Fire Marshal Division

Re: Bourbon Street Bar and Grill
410 Pine Street
Lillington, NC 27546

Application Number FMFW2008-0001

Thank you for submitting the plans for the hood system. The plans have been carefully reviewed by a qualified code enforcement official to examine for compliance with the North Carolina Fire Prevention Code and all other fire protection regulatory documents. There are some items that were found during the plan review process that need to be addressed before a final inspection of the new facility can be given. These items are outlined and described below.

JOB NAME Bourbon Street Bar & Grill 410 Pine Street Lillington, NC	
DESCRIPTION Wet-Chem Fire Suppression	
CONTRACT WITH Bourbon Street Bar & Grill	
JOB # 19385472	FILE NAME 19385472
DRAWN BY LEE CAUDILL ,CET Fire Alarm Systems, LEVEL III NICET #113371	DATE 8-4-2020 SCALE NTS
DWG # 1 of 1

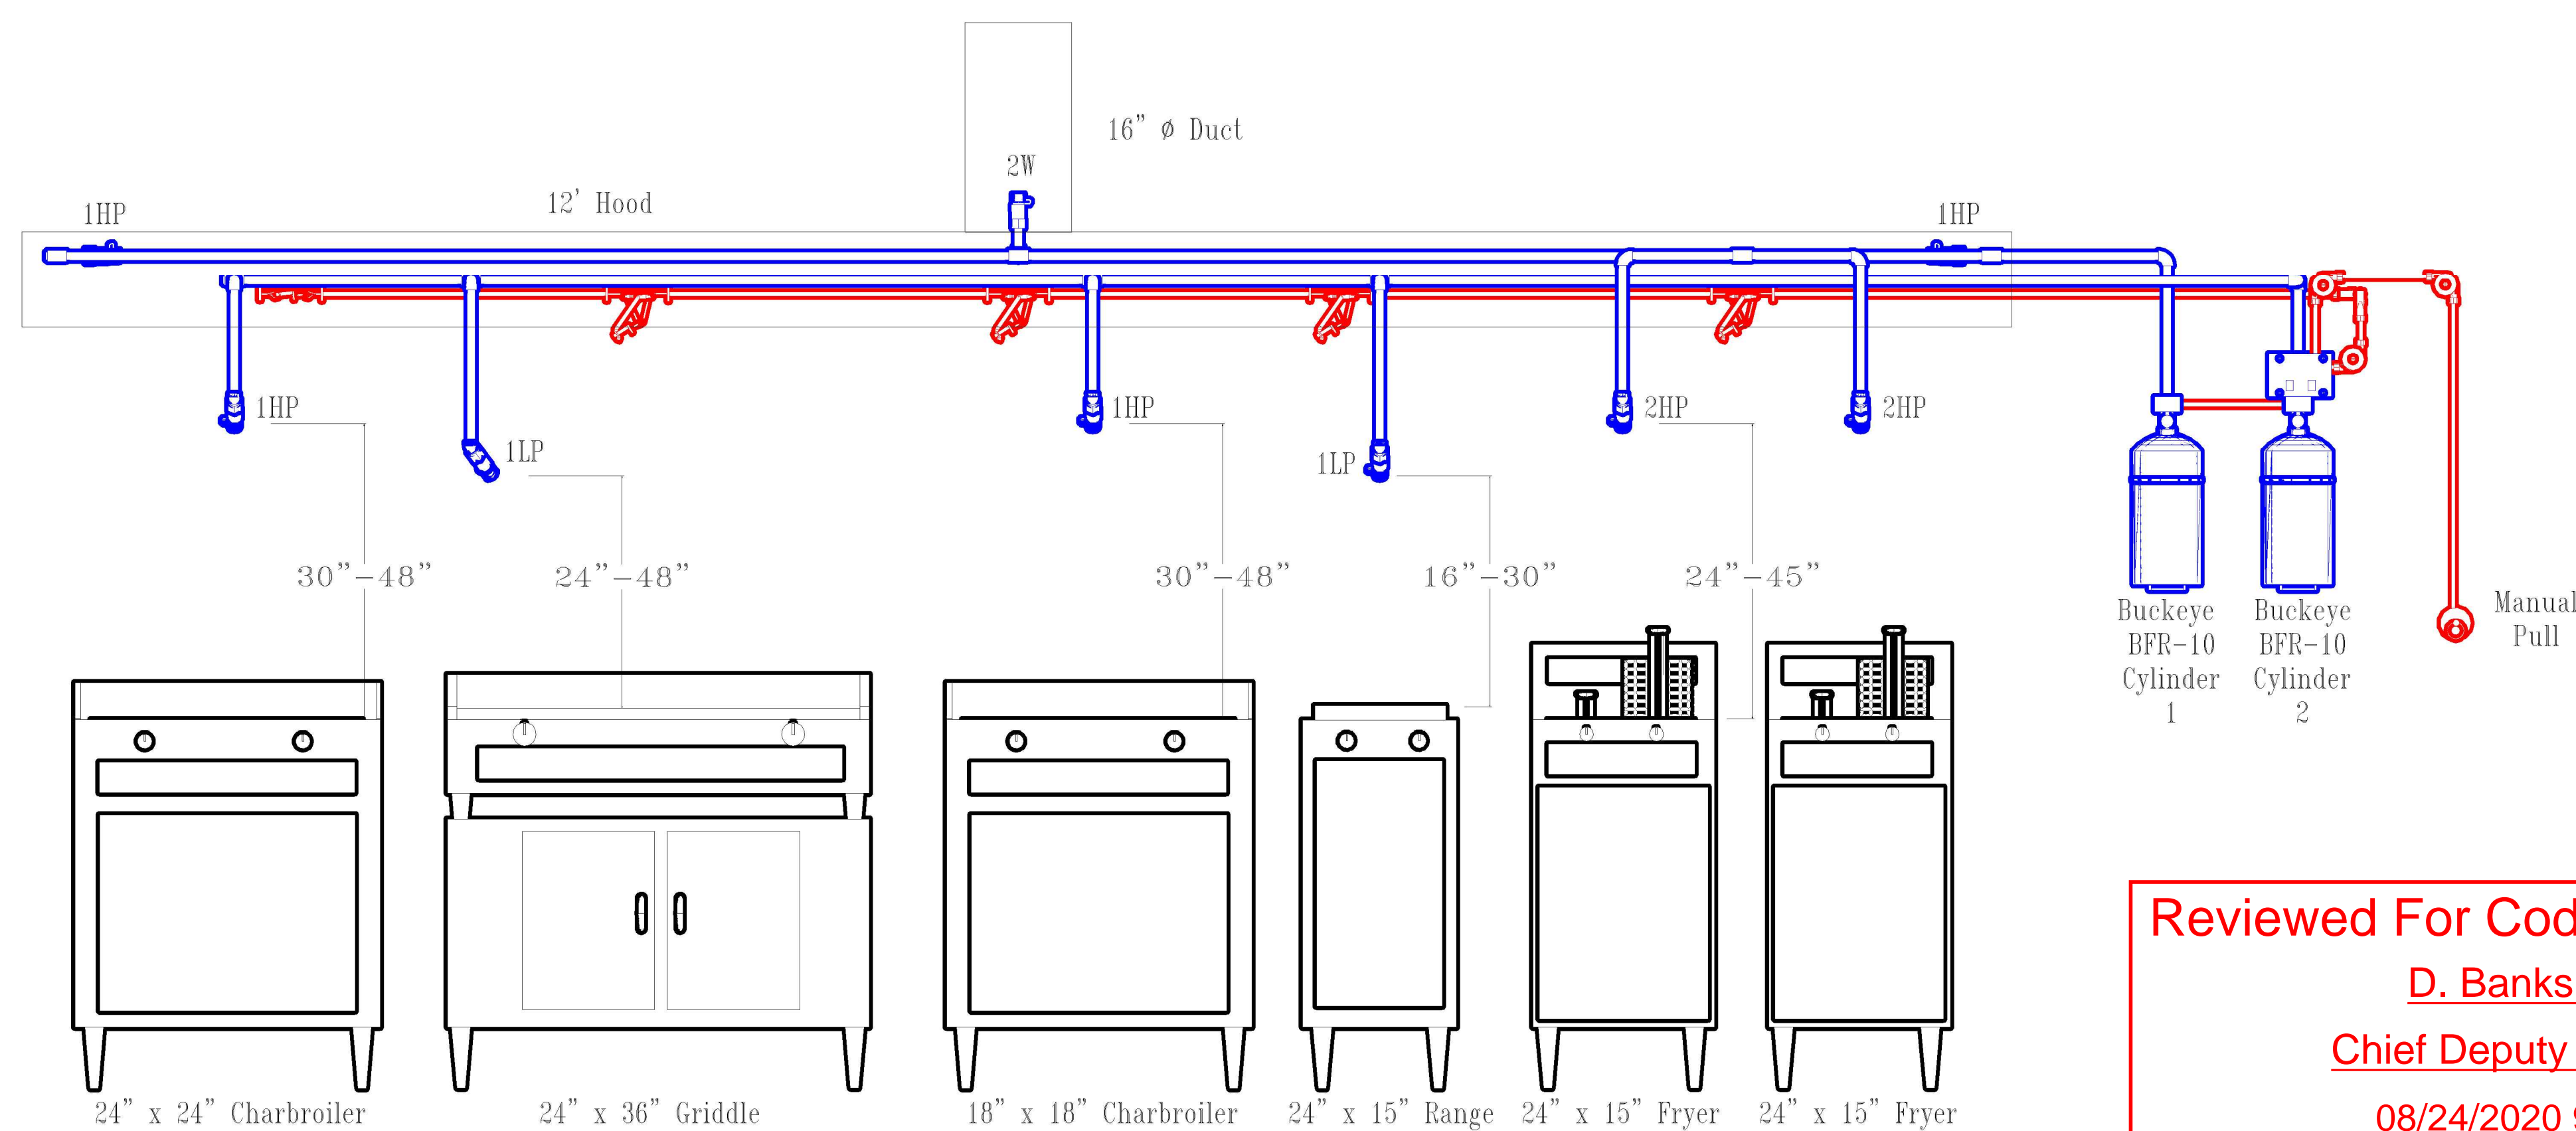
- **Commercial cooking equipment.**
 - Portable fire extinguishers shall be provided within a 30-foot (9144 mm) travel distance of commercial-type cooking equipment. Cooking equipment involving vegetable or animal oils and fats shall be protected by a Class K rated portable extinguisher.
- **Acceptance Test**
 - An acceptance test will be conducted by the Fire Marshal's office once system has been installed and pre-tested.
 - Installation shall be per architectural and system submittals and compliant with NFPA-17A.
- **Manual system operation**
 - A manual actuation device shall be located at or near a means of egress from the cooking area, a minimum of 10 feet (3048 mm) and a maximum of 20 feet (6096 mm) from the kitchen exhaust system. The manual

actuation device shall be located a minimum of 4.5 feet (1372 mm) and a maximum of 5 feet (1524 mm) above the floor. The manual actuation shall require a maximum force of 40 pounds (178 N) and a maximum movement of 14 inches (356 mm) to actuate the fire suppression system.

- **System Interconnection**

- The actuation of the fire suppression system shall automatically shut down the fuel or electrical power supply to any equipment under the hood system. The fuel and electrical supply reset shall be manual.
